**From:** Hill, Grace <Grace.Hill@e-lindsey.gov.uk>  
**Sent:** 09 April 2026 15:08  
**To:** Allen, Daniel  
**Cc:** \_planningadvice  
**Subject:** H23-0171-26 ecology comments

H23-0171-26 – Land Off Stockwell Gate Whaplode Spalding  
Residential Development of 5 Bungalows - outline approval H23-0827-22

Summary: While sufficient evidence has been submitted to determine the application, there is insufficient information at this time to confirm whether mandatory 10% Biodiversity Net Gain would be delivered on-site or off-site.

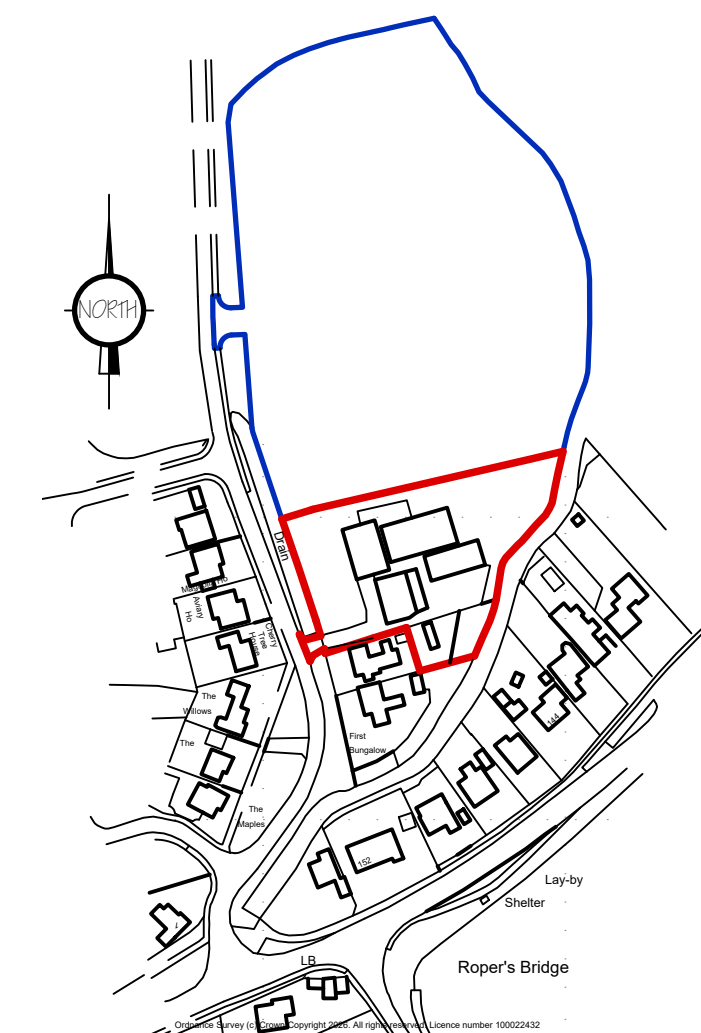
- We request that a total of 5 integrated universal nest bricks (e.g., S Brick, Swift Nesting Brick, Manthorpe, Swift Bricks: The ‘Universal’ Nest Brick – by Dick Newell | CIEEM) are incorporated into the external fabric of one or both buildings. These should be located at a height of 4+ m metres, on the north or east elevations to avoid overheating, and grouped colonially where possible, in accordance with best-practice guidance such as British Standard BS 42021:2022. The bricks must be installed during the construction phase and retained thereafter for the lifetime of the development.

- We also request that two integrated bat box (e.g., Integrated / Built-In Bat Boxes, Integrated Eco Bat Box | The Nestbox Company) are added to the development.

- In both cases, the authority requires the applicant to submit sufficiently detailed maps that indicate the proposed location of bird/bat boxes on-site. These are required to enhance biodiversity and to be in line with Local Plan Policy 7.2.14.
